Appeal Decision

Appeal Ref: APP/T2350/W/23/3333973

Land to the south of Chatburn Old Road, Chatburn, Clitheroe

- The appeal is made under section 78 of the Town and Country Planning Act 1990 (as amended) against a refusal for Technical Design Consent.
 - The appeal is made by Mr Ronald Jackson against the decision of Ribble Valley Borough Council.
 - The application Ref is 3/2022/0500.
The development proposed is Technical Details Consent application following on from Permission in Principle for land to the south of Chatburn Old Road, Chatburn. Site adjoining rear boundaries of Crow Trees Brow, High Beech House and recently approved/developed Hare Hill Croft.
-

Drawing file: planx_downloads / 22_0500_Plot_7_Floor_Plans.pdf

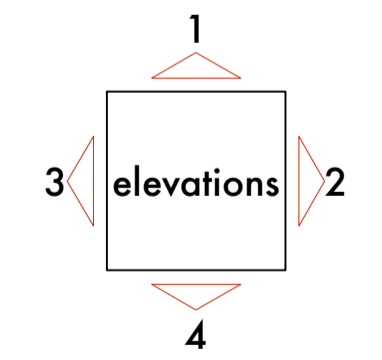
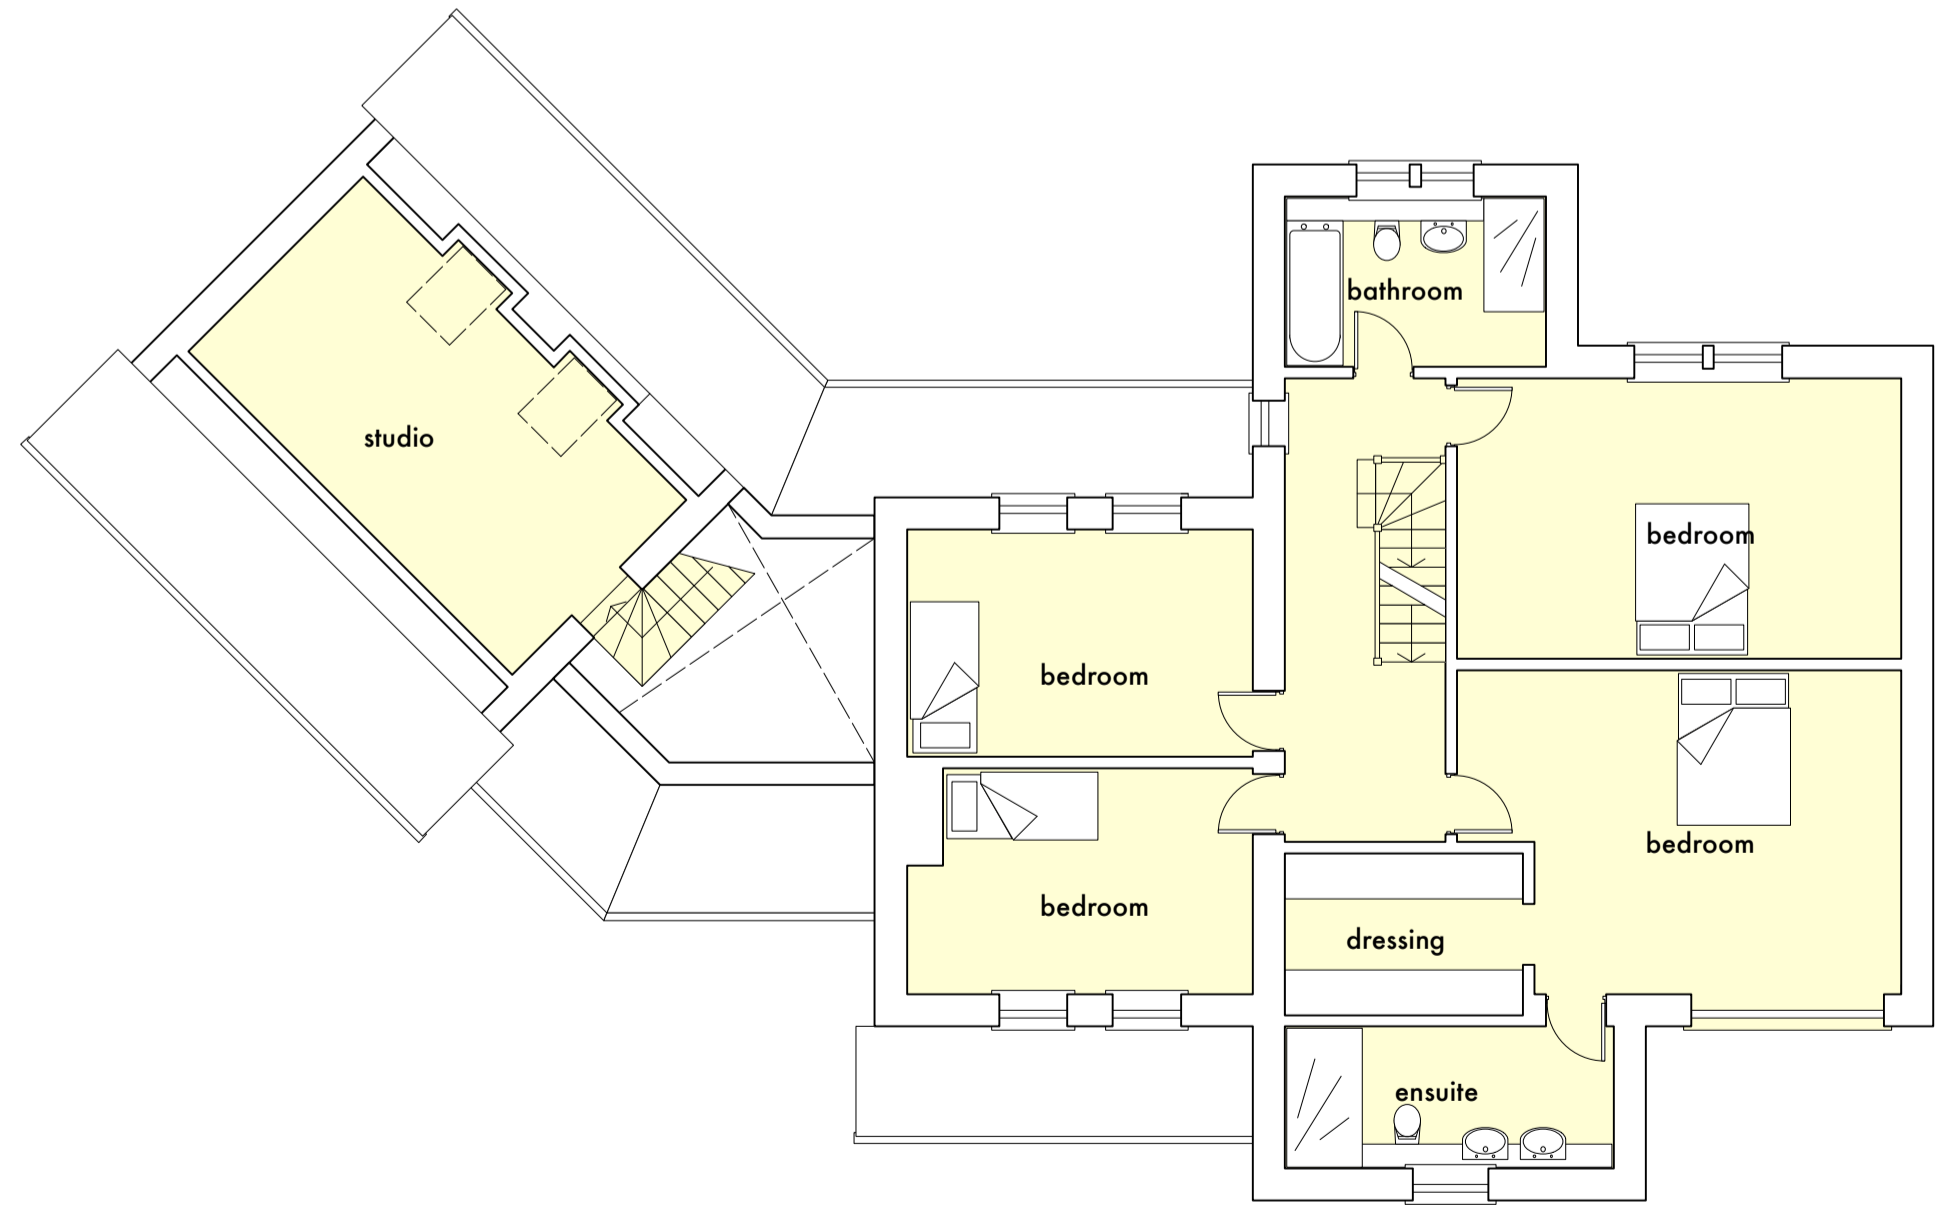
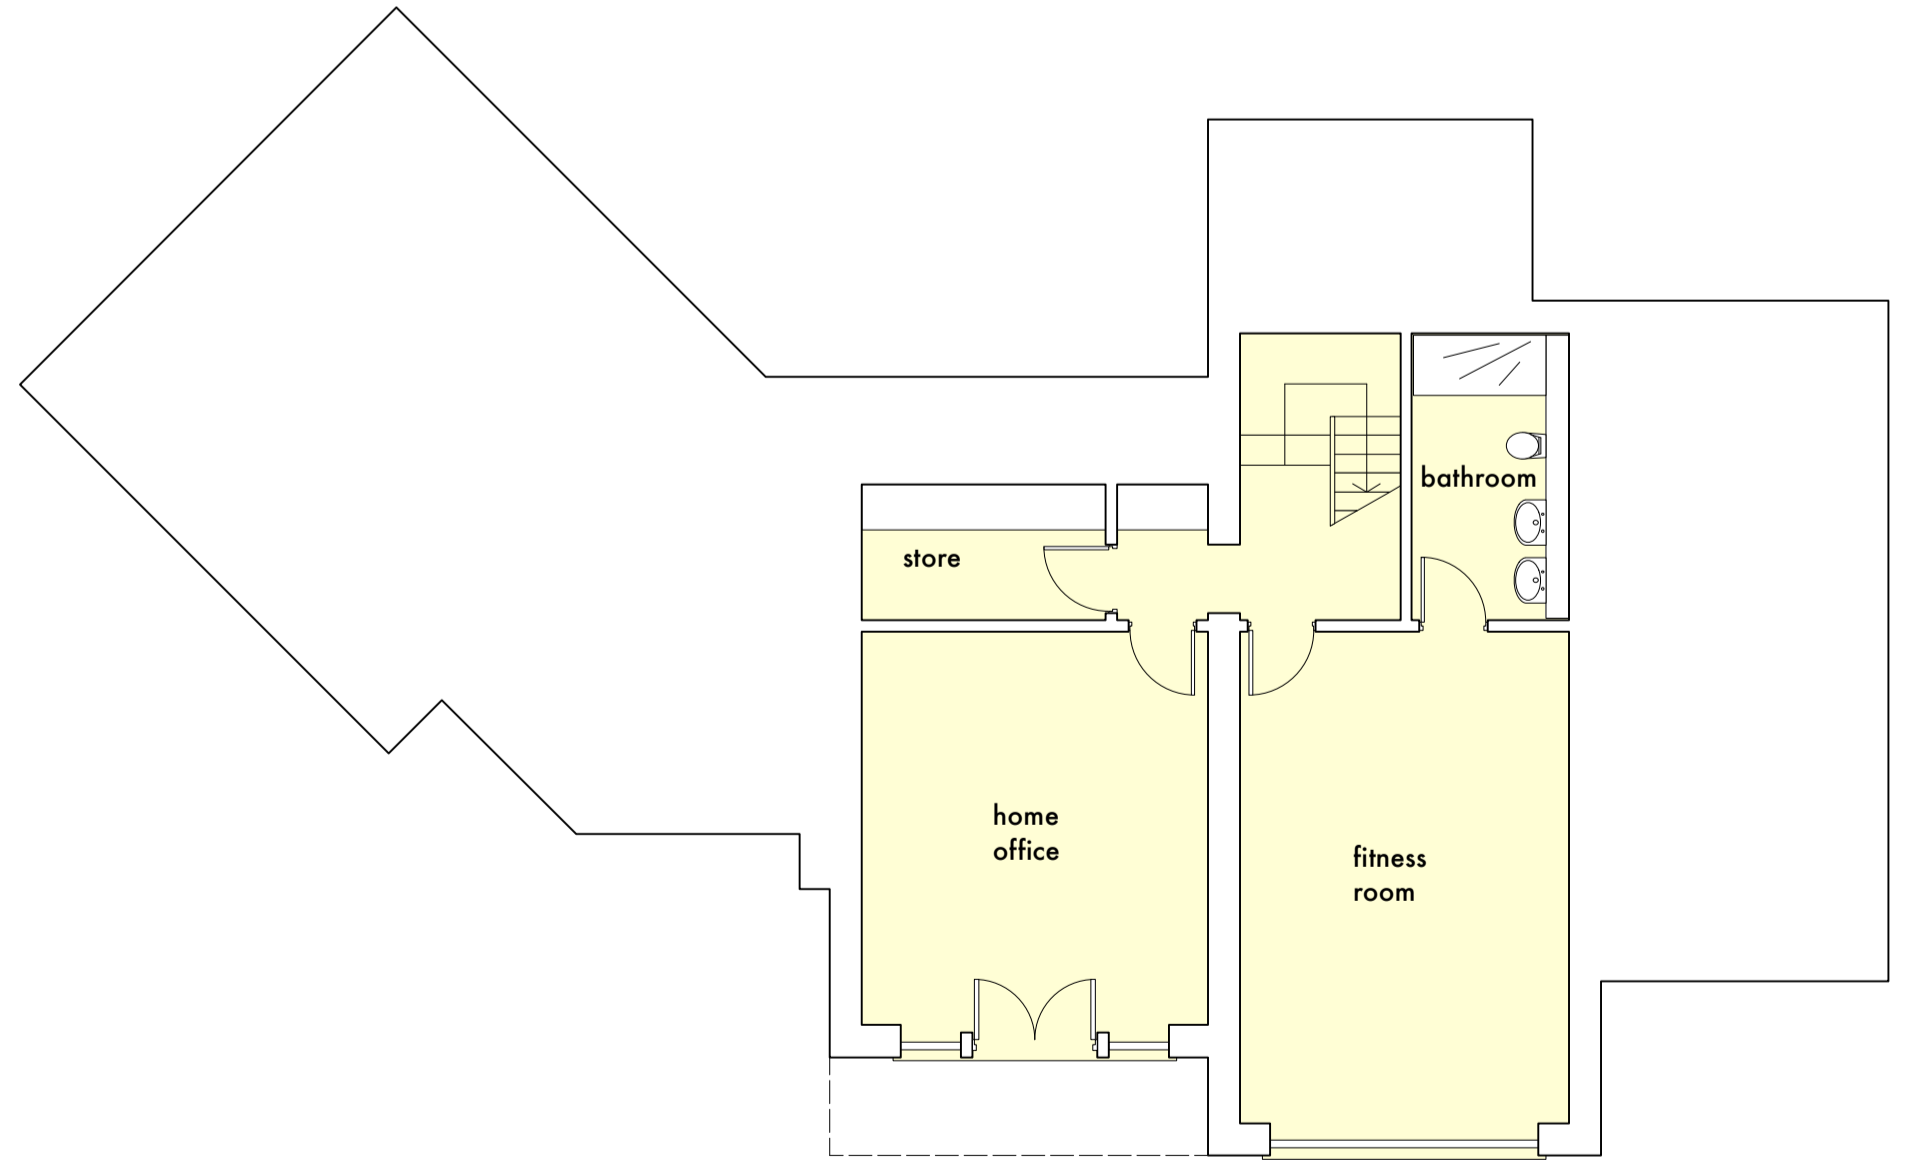
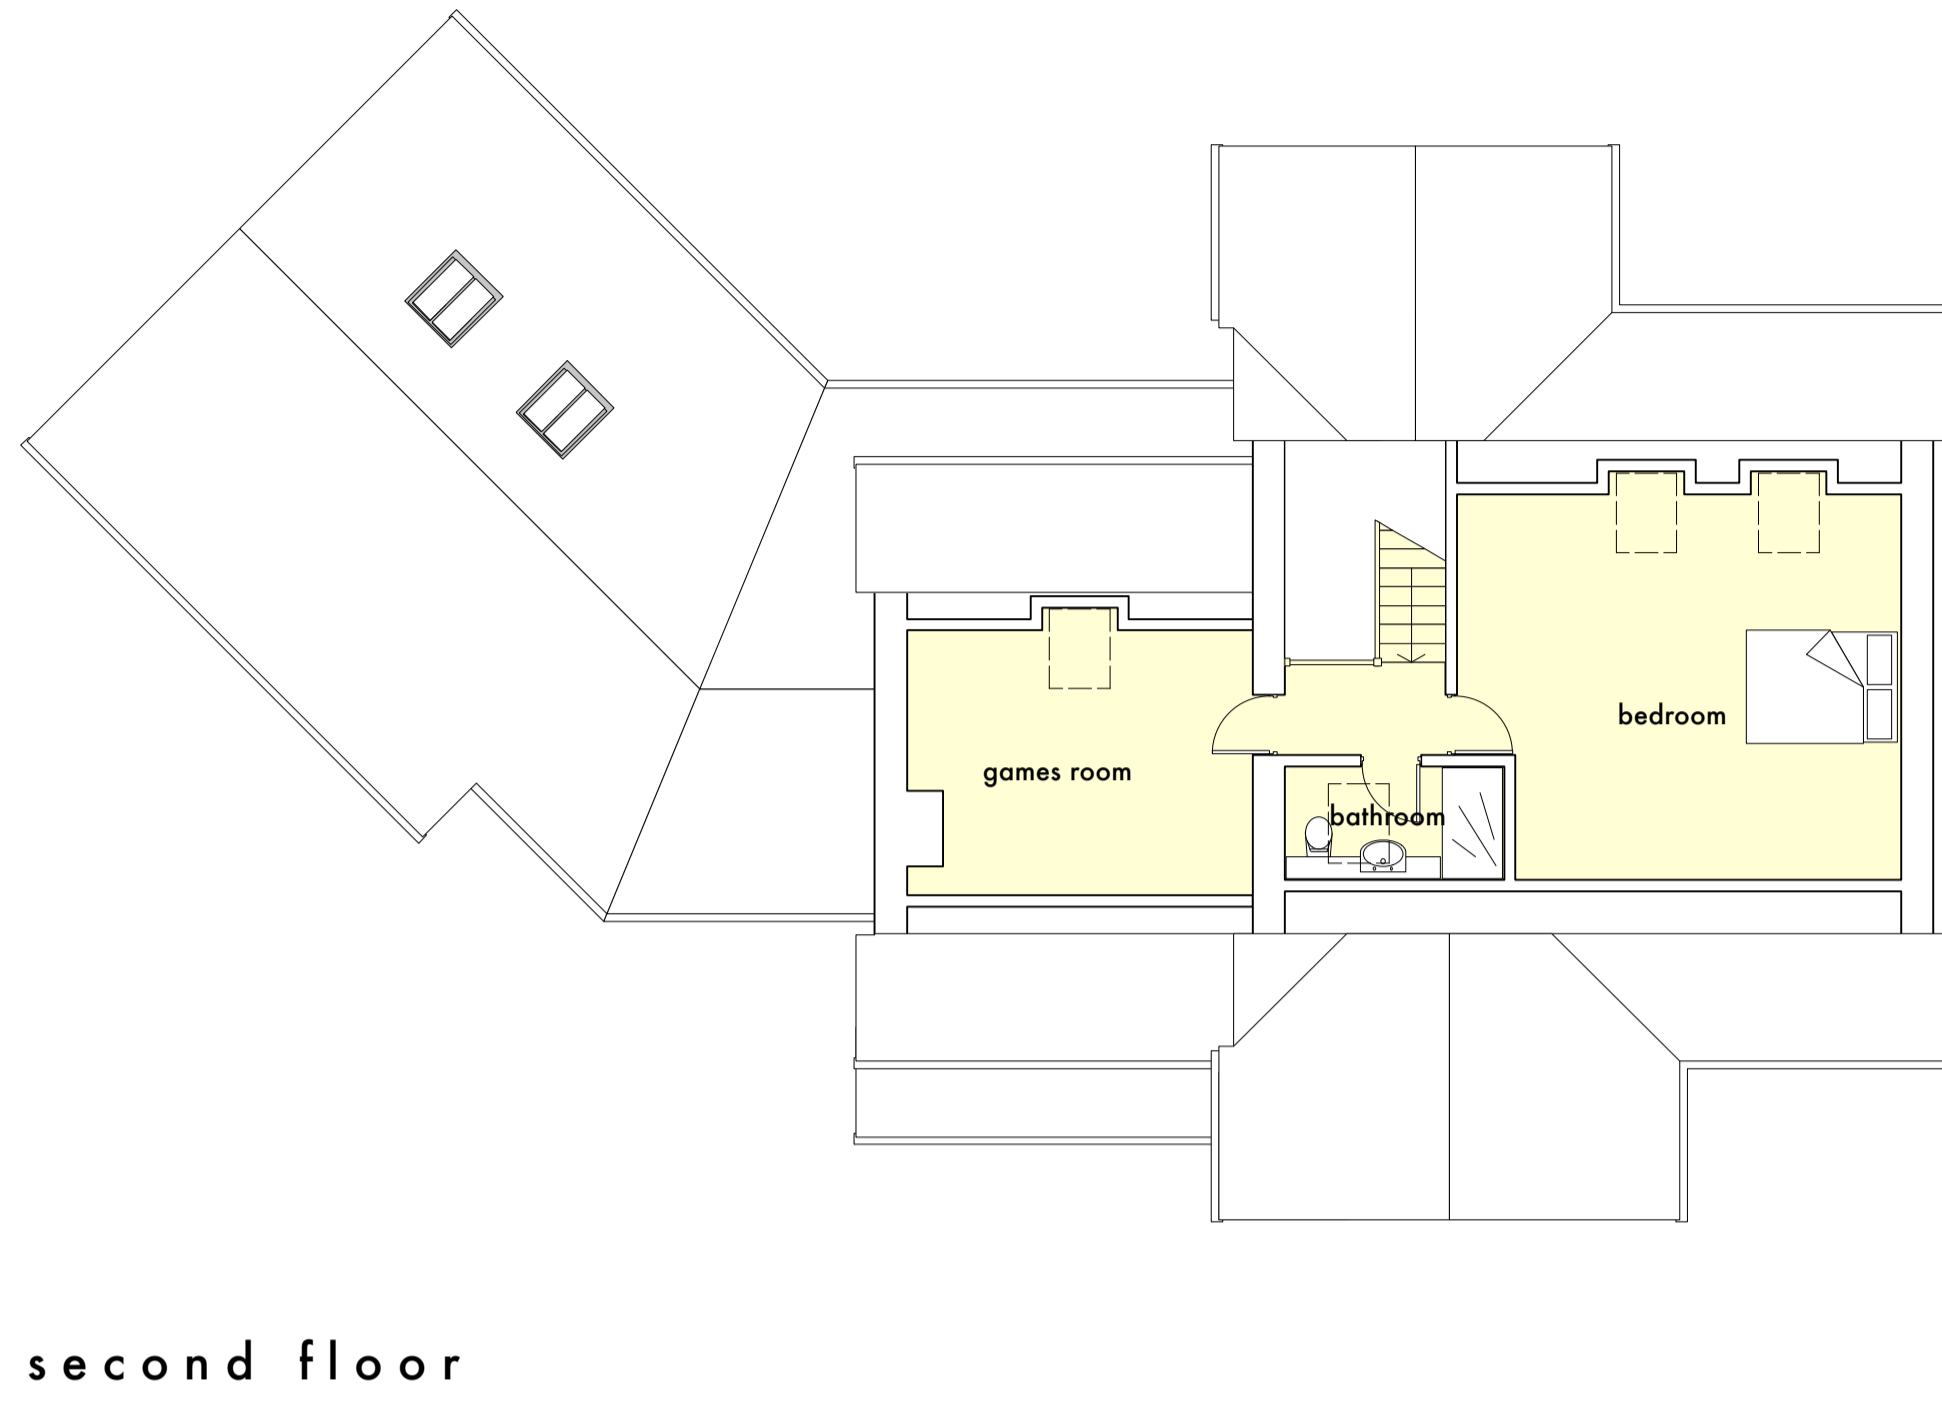
40. The rear elevation for No 7, incorporates floor to ceiling glazing and a balcony, which serve habitable rooms at ground floor, and a first floor bedroom. Based on my observations these, in particular those closer to the boundary with No 26, would allow extensive views over the rear garden of No 26, which would not be limited to the top parts of the garden.

41. Also, some of the windows and the balcony at No 7, serve living, dining and kitchen areas, which are likely to be in use in the day, when the garden associated with No 26 is also likely to be used. The presence of outbuildings / garden structures at No 26 are of limited sizes and would be largely screened by the fence. As such, these and any boundary planting would offer a very limited visual break in the extensive views from the ground and first floor accommodation at No 7.

42. I acknowledge that some mutual overlooking is expected in residential areas. Even so, in this instance the siting of No 7, would be particularly intrusive by introducing a substantial and unacceptable degree of overlooking of the rear garden of No 26. This would significantly undermine the living conditions of the occupiers of this dwelling. As such, the proposal would conflict with Policy DMG1 of the CS, which seeks to protect existing and future residential amenities from undue detrimental impacts.
